30 June 2017

**Hume Coal Project (SSD 7172) and Berrima Rail Project (SSD 7171)**

I refer to your e-mail dated 31 March 2017 inviting WaterNSW to make a submission, including recommendations, on the Environmental Impact Statements (EIS) for the Hume Coal Project and related Berrima Rail Project. WaterNSW's primary concerns with the EISs are listed below, with more detailed comments provided in the attachments.

Project water table drawdown: Year 1 - Year 6
 Hume Coal Project
 Water Assessment
 Figure M.1a (Appendix M)

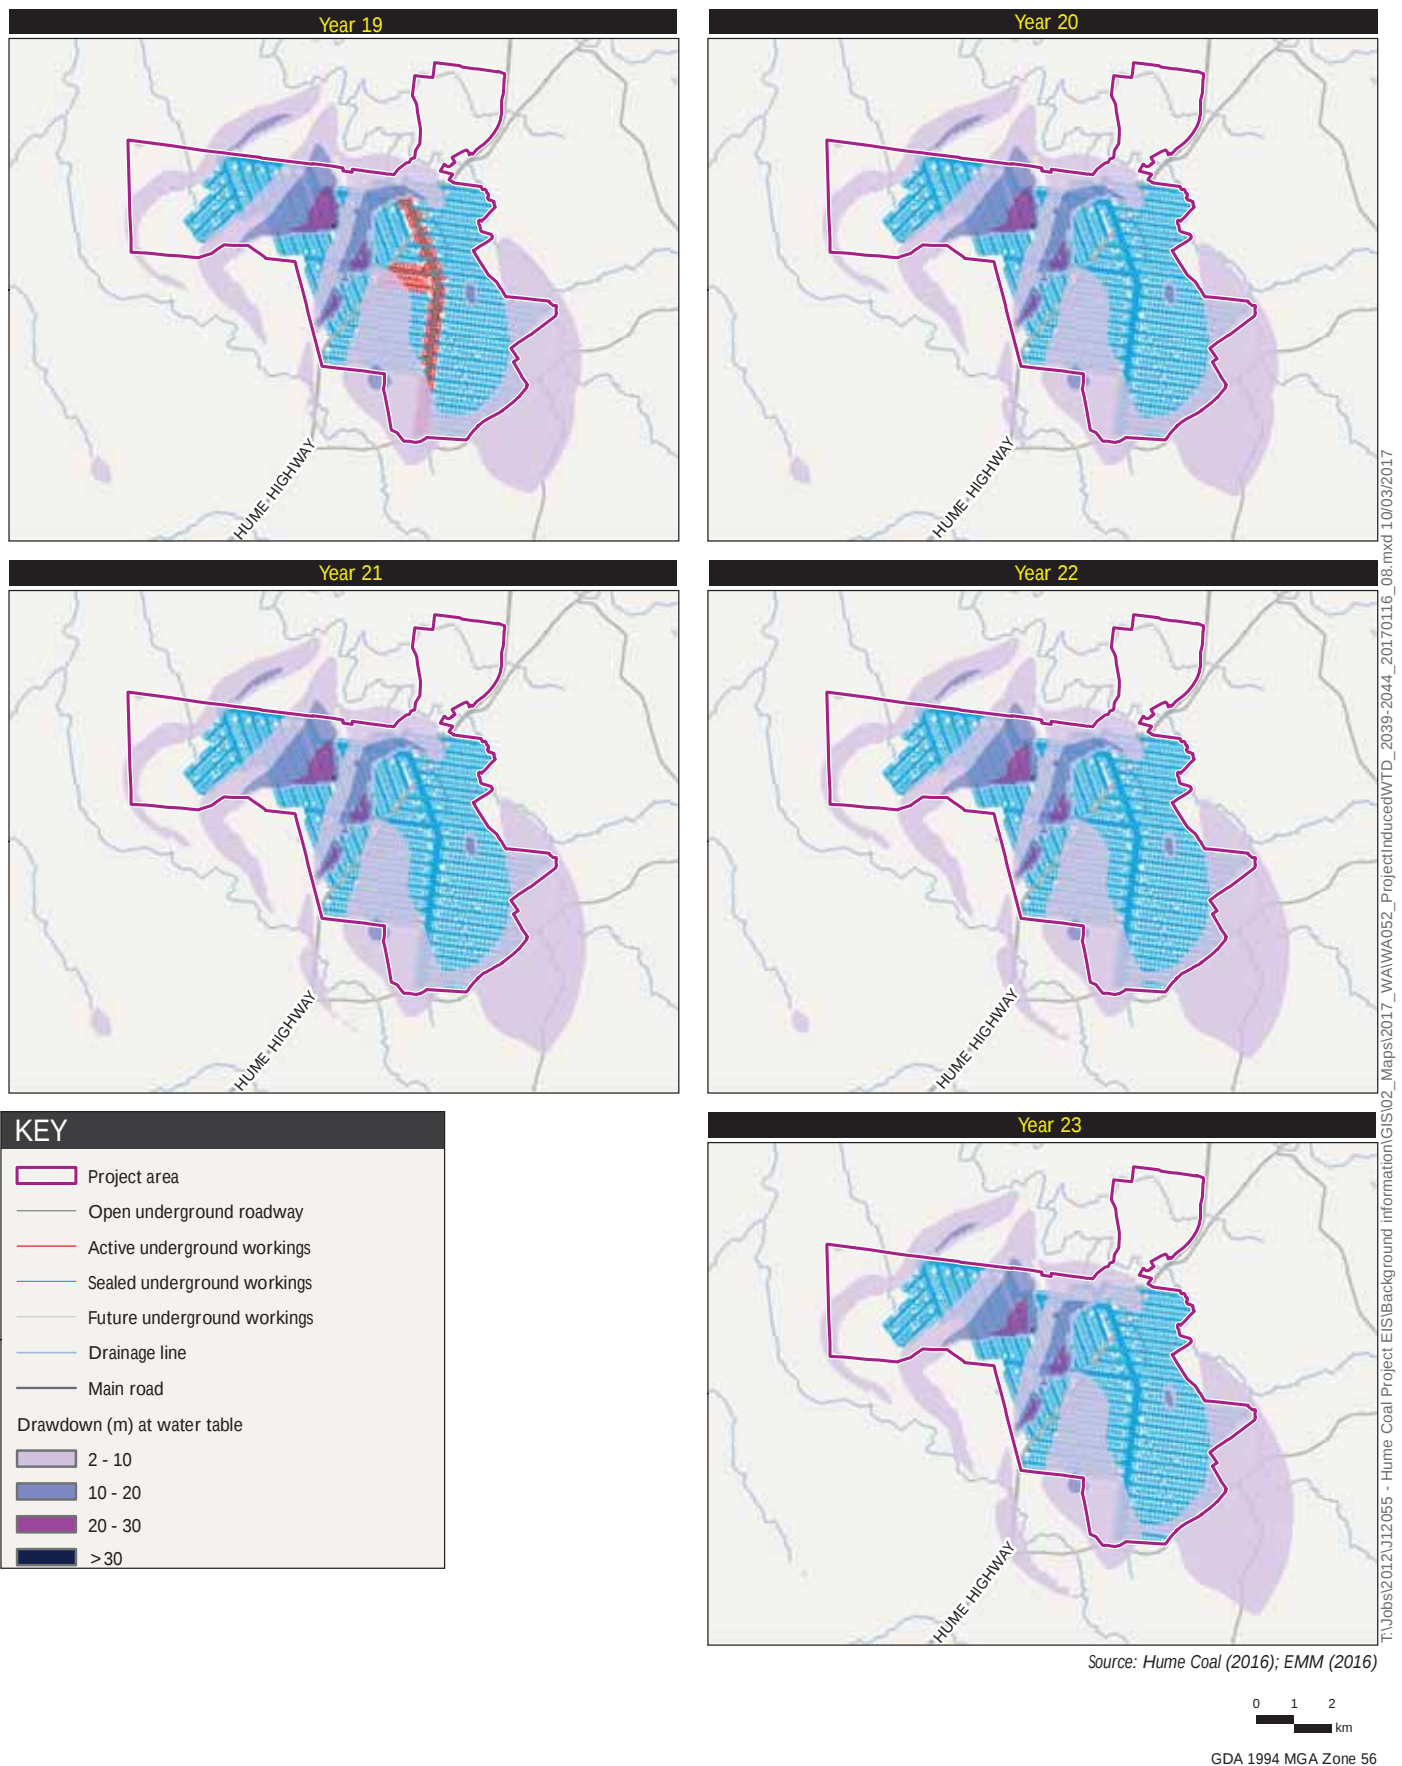
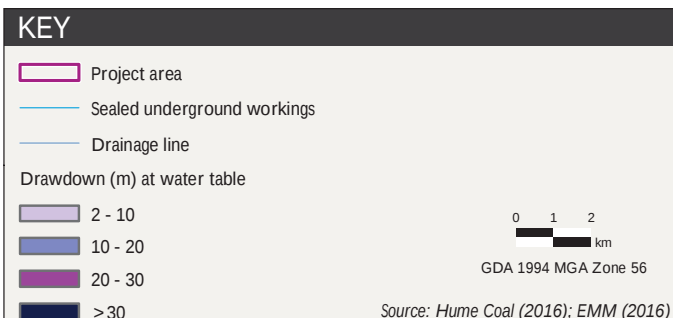
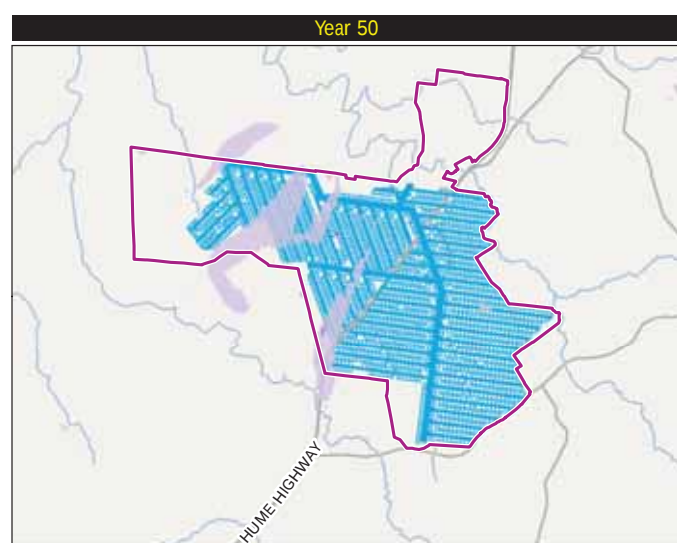
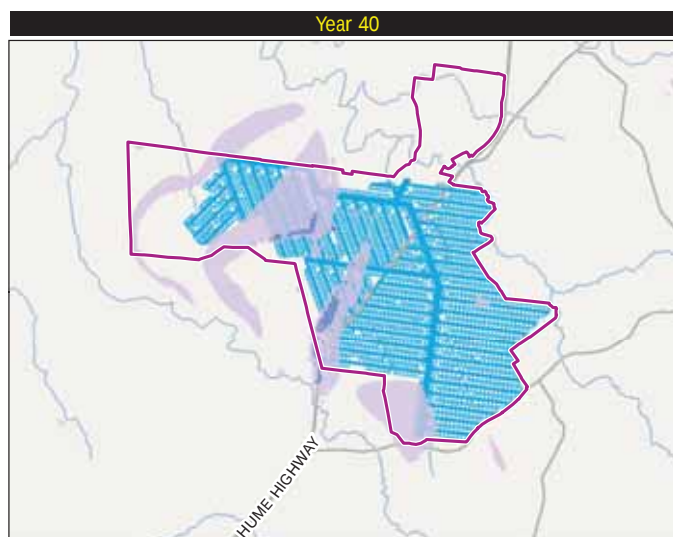
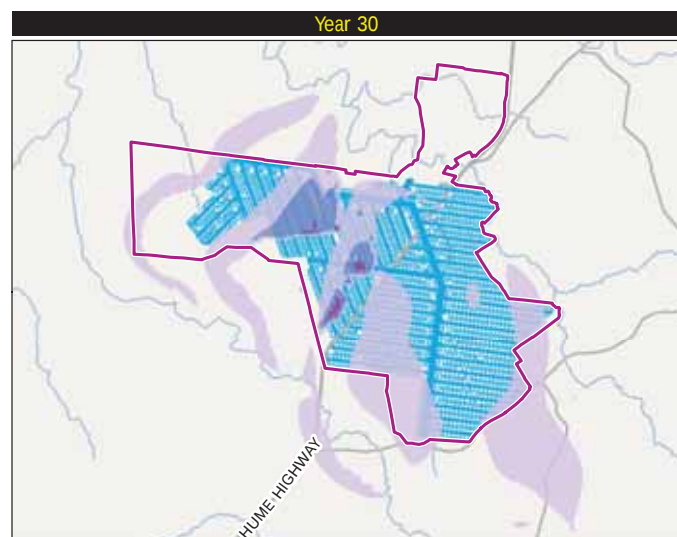
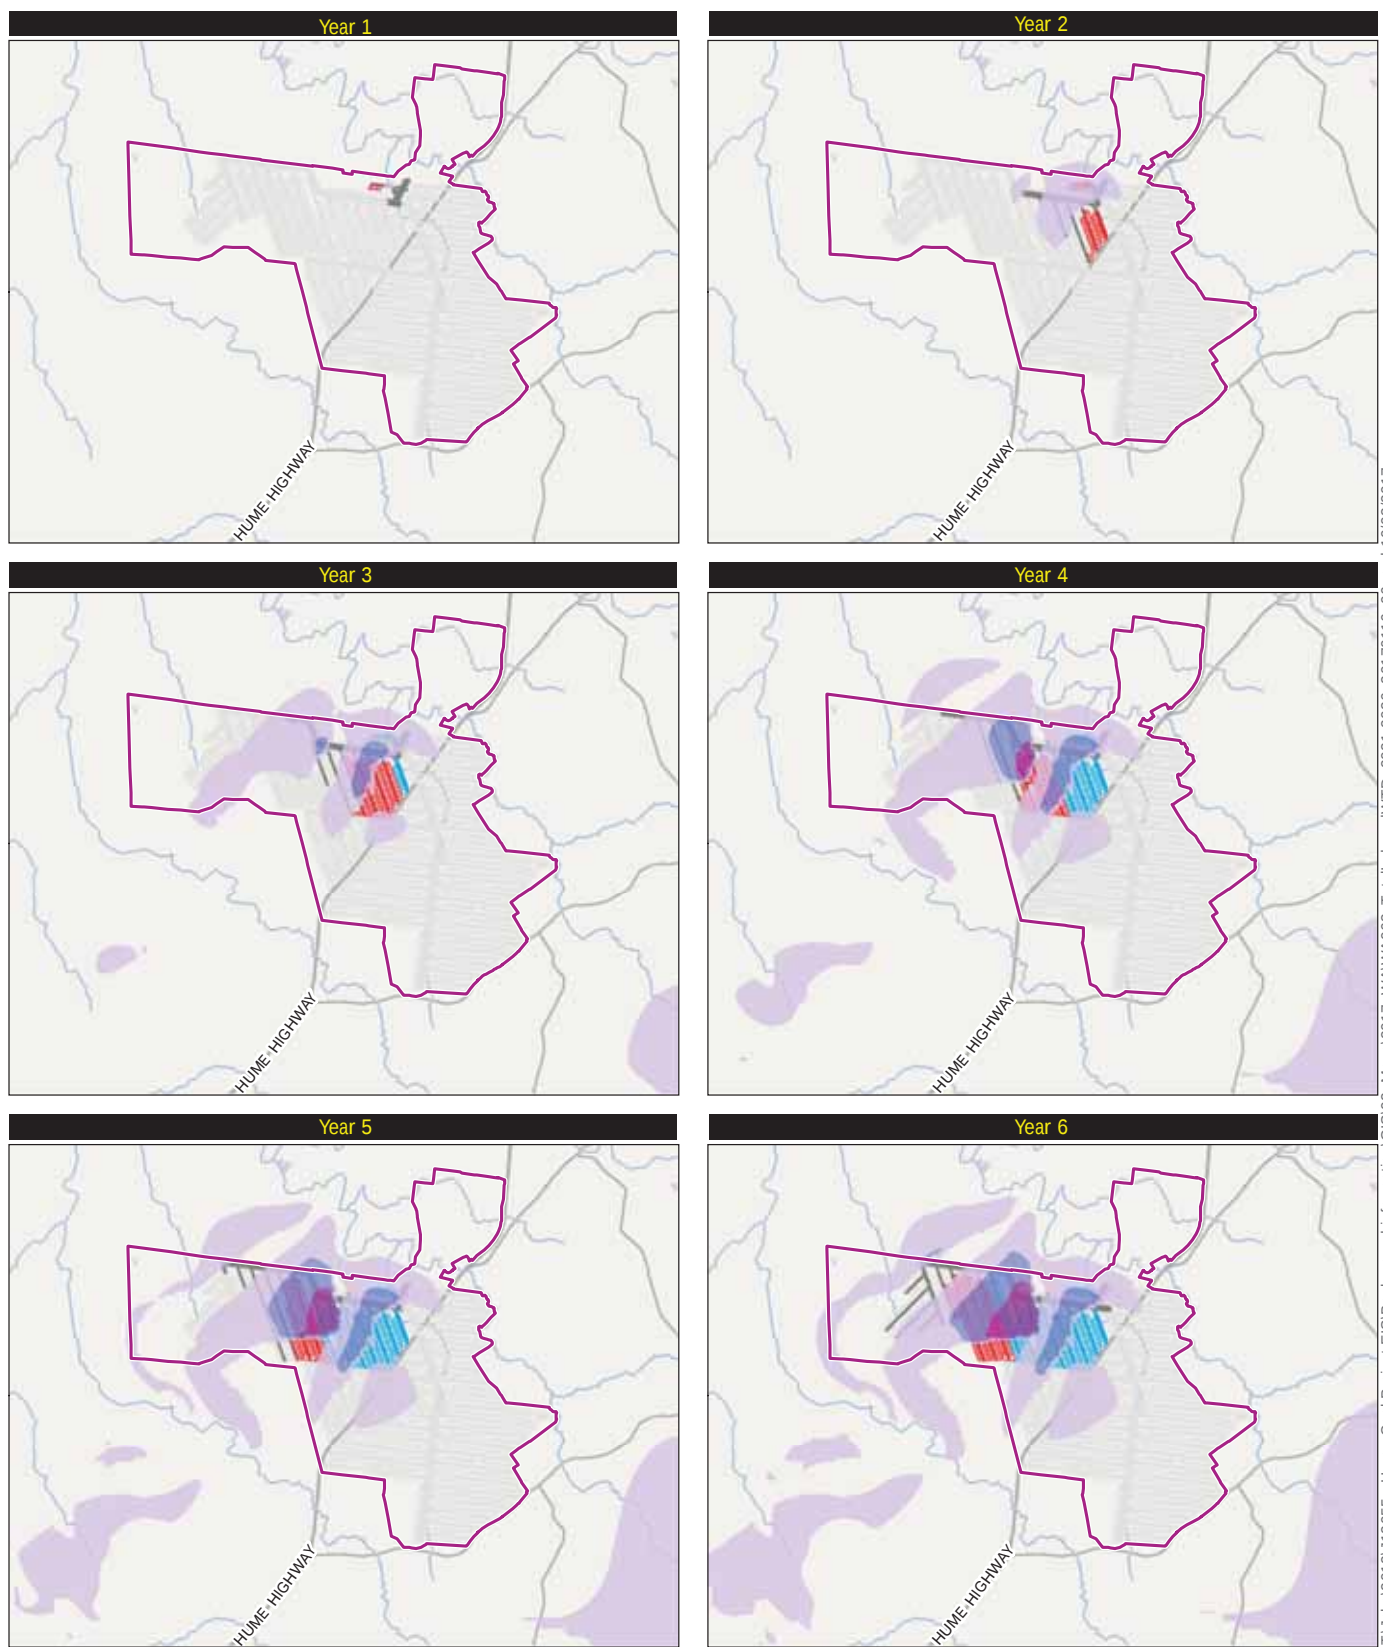
- The hydrogeological modelling supporting the Hume Coal EIS appears likely to underestimate the reduction in groundwater levels and baseflows, particularly during extended drought, which is a significant concern to WaterNSW. A prediction of these outputs including worst-case (extended drought) sensitivity testing of the groundwater model should be undertaken.

The groundwater assessment, including predictions of drawdown and impacts on stream baseflows, is based on steady-state predictive modelling. This effectively means that these parameters are predicted as averages. Although the groundwater modelling calibration used dynamic (transient) rainfall and groundwater levels, the drawdown and baseflow impact predictions made by the groundwater model does not account for rainfall variability. It therefore appears likely to underestimate baseflow losses and water table declines during drought periods (see Attachment 2 for details). The water balance modeling also used average mine water flow estimates (see Attachment 3 for details) and does not consider groundwater level variability due to climatic effects and drawdowns induced by other users, particularly in extended drought periods.

Use of average rainfall input, rather than probabilistic or worst-case scenario ranges, makes derived groundwater impact predictions non-conservative/optimistic for dry periods. **This lack of conservatism is a significant concern to WaterNSW and should be addressed, e.g. through additional worst-case sensitivity testing of baseflow and groundwater level reductions on neighboring bores, prior to the Department's assessment of the Project.**
